I would like to register to comment both as a local resident and as a representative of the HALT local campaign group.

ISH1 5a) Socio & Environmental Matters

**Figure 14.6: Proposed BESS Alongside Excerpt from the ALC Map**

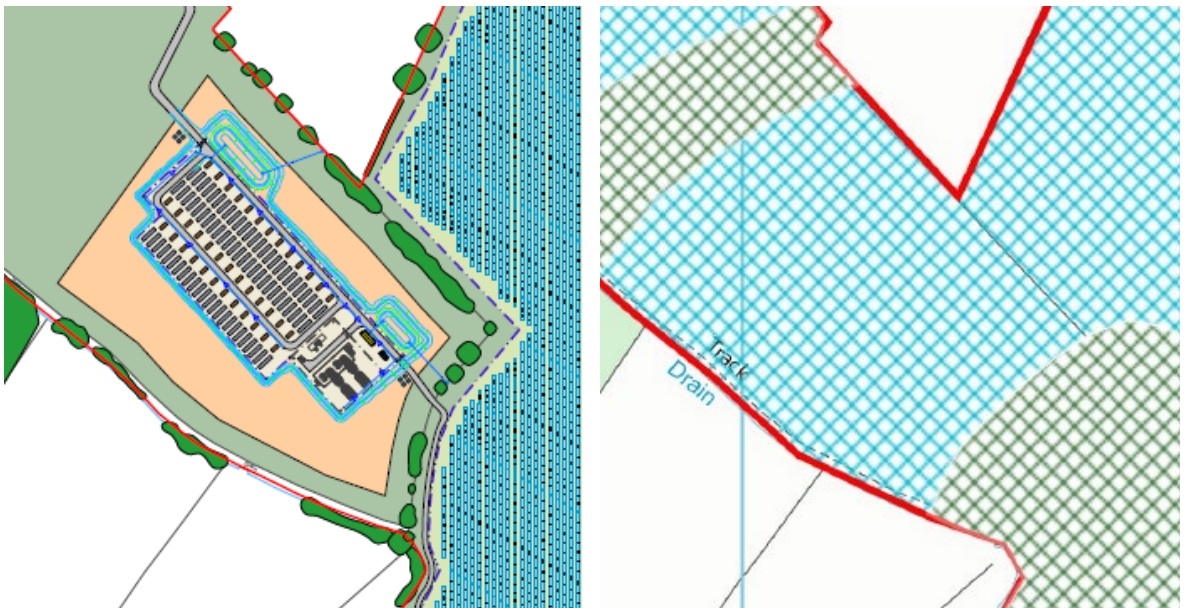
The BESS proposed is in very close proximity to the houses on both Hardenshaw Lane and Chestnut Court, which sit on

the edge of the village of Camblesforth. This brings huge concerns to those living closest, as the potential risks of fire and air pollution as a result, very much make us sitting ducks. If there were to be such a fire we can expect that highly toxic gases such as Hydrogen Fluoride would be emitted. This can spread at dangerously high levels over distances of 1-2 miles, even without taking into account the wind factor (we see a prevailing wind directly over this area that would potentially take such pollutants straight to the main village of Camblesforth).

When asked about the location of the BESS, the Enso representative informed us that the position had been selected as it was central to the site. Although I appreciate that

BESS should be located with due considerations of impact on communities, sites and infrastructure. Prevailing wind directions (which we experience in this location) should be factored into the location of the BESS to minimize the impact of a fire involving lithium-ion batteries due to the toxic fumes produced.

Enso recognize in their documentation that the infrastructure such as BESS and the onsite substation do have the potential to create noise and have been located towards the centre of the site, away from residential properties for this reason. Hardenshaw Lane and Chestercourt lie on the outskirts of the village, they are still homes to a number of residents, and yet as residents, we do not appear to have been considered at all, our safety or well-being in terms of noise implications, do not appear to matter, nor those of the wider Camblesforth community, who could also be impacted upon if a fire were to happen.
